WELWYN HATFIELD COUNCIL – DEVELOPMENT CONTROL
DELEGATED REPORT

APPLICATION No:	S6/2011/1397/FP
------------------------	------------------------

The proposed development would involve an extension to the northern flank wall of the dwelling. The proposal would measure 7.74m in depth by 2.86m in width and would adjoin the main roof to create a gable end with a new chimney. The application also involves the demolition of a garage to reduce some of the built development within the application site.

Proposed Elevation on Arrow D
1:100

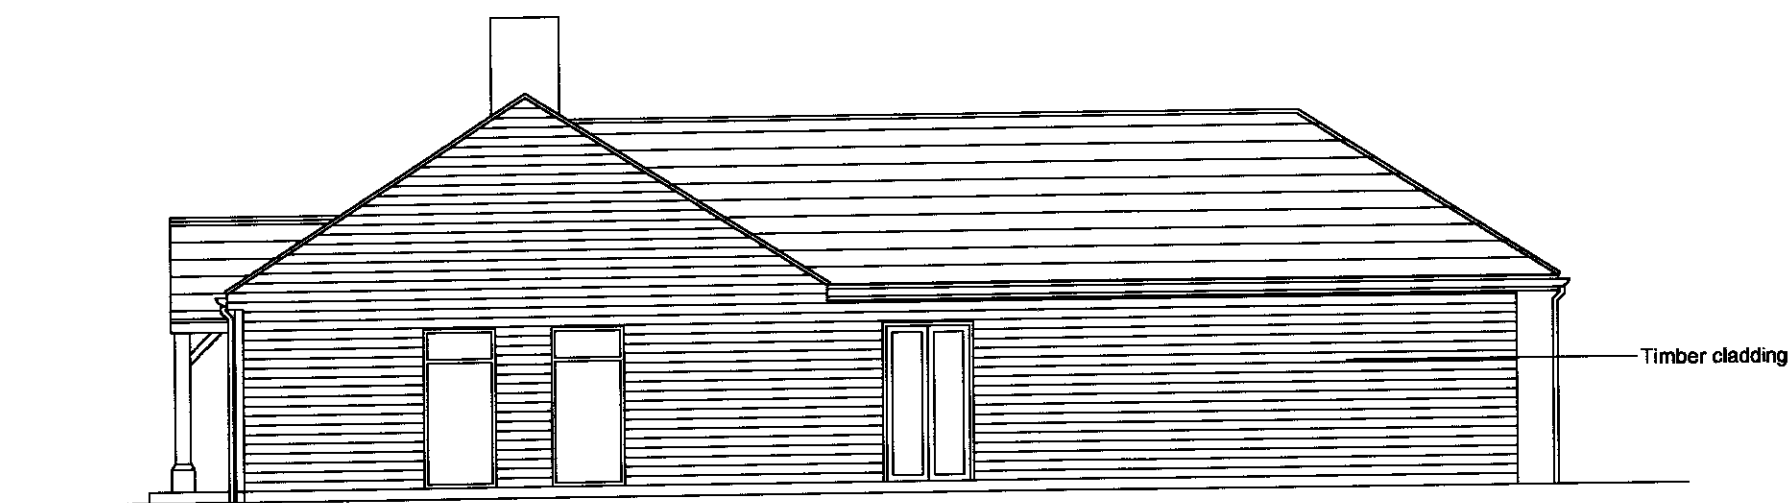
The application dwelling has been previously extended significantly, with an extension which has added roughly 63sq.m. The original dwelling had a floorspace of 116sq.m and therefore the property's floorspace has been increased by approximately 54% as existing. The proposed development would have a floor area of 22.1sq.m and the resultant dwelling would have a floorspace of 202.5sq.m. Therefore, the resultant increase in floorspace would equate to 74.6% when compared to the original dwelling.

When viewed individually the proposed extension's projection and floor area would be subordinate in scale and would attach well of the existing dwelling. The proposed chimney and gable end would add to the bulk and mass of the dwelling and this would be a large increase when compared to the original dwelling. From a design point of view the resultant dwelling would not be significantly more harmful than the existing dwelling. Due to the siting of the dwelling the proposed extensions would not be viewed prominently or appear dominant from the surrounding public areas and the resultant dwelling would not have a significantly greater impact upon the visual amenity of the area. Therefore, although the proposal would increase the bulk and massing of the property which conflicts with Policy RA3(i), the appearance and quality of design and appearance of the proposal would not conflict with the requirements of design Polices D1 and D2 of the Welwyn Hatfield District Plan 2005.
